Reference No: 2020/62/90492/W

Site Address: 27, Hill Grove, Salendine Nook, Huddersfield, HD3 3TL

Description: Erection of single-storey and first-floor extensions to rear, formation of pitched roof, and erection of front porch (modified proposal)

DECISION - REFUSED

PROPOSED GROUND FLOOR

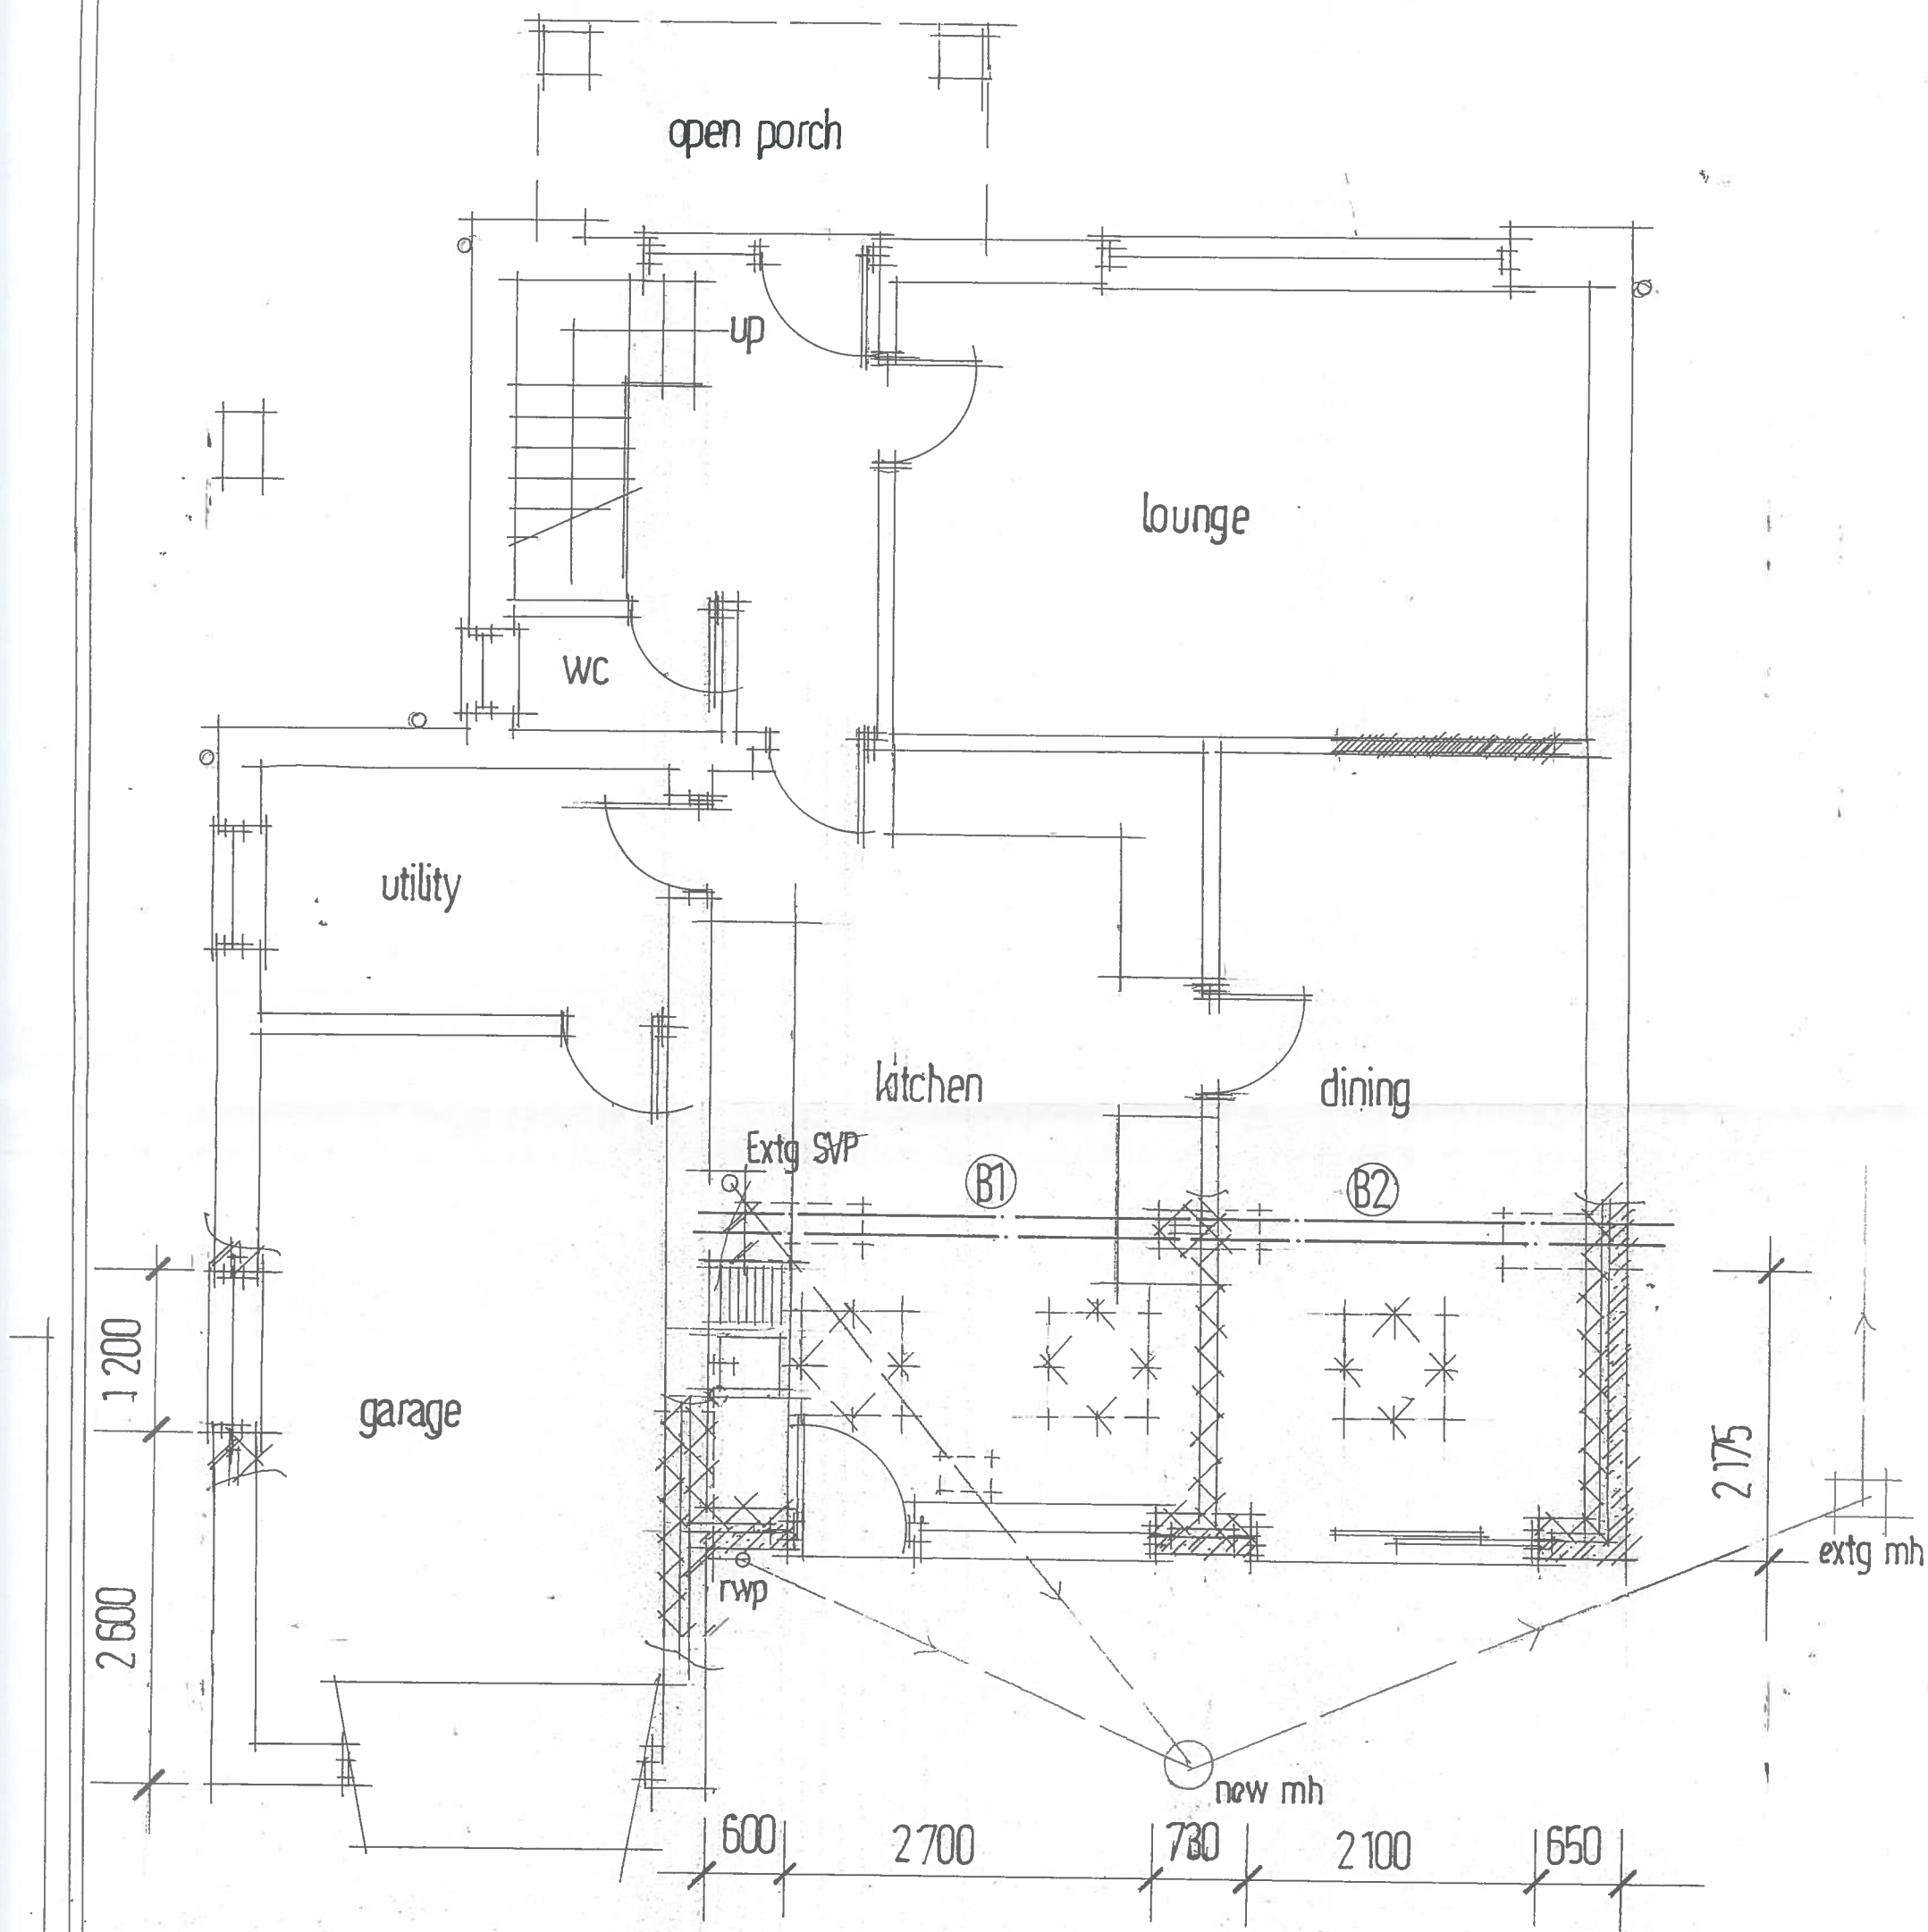
The ground floor extension would project 2.1m and would be the full width of the remaining part of the ground floor elevation, and with a lean-to roof joining the main wall at a height of 3.5m. Proposed materials are stone and tiles.

As before, some elements of the scheme – in particular the formation of a pitched roof – would improve the appearance of the property overall, and the ground floor extension and porch are judged acceptable in scale and design.
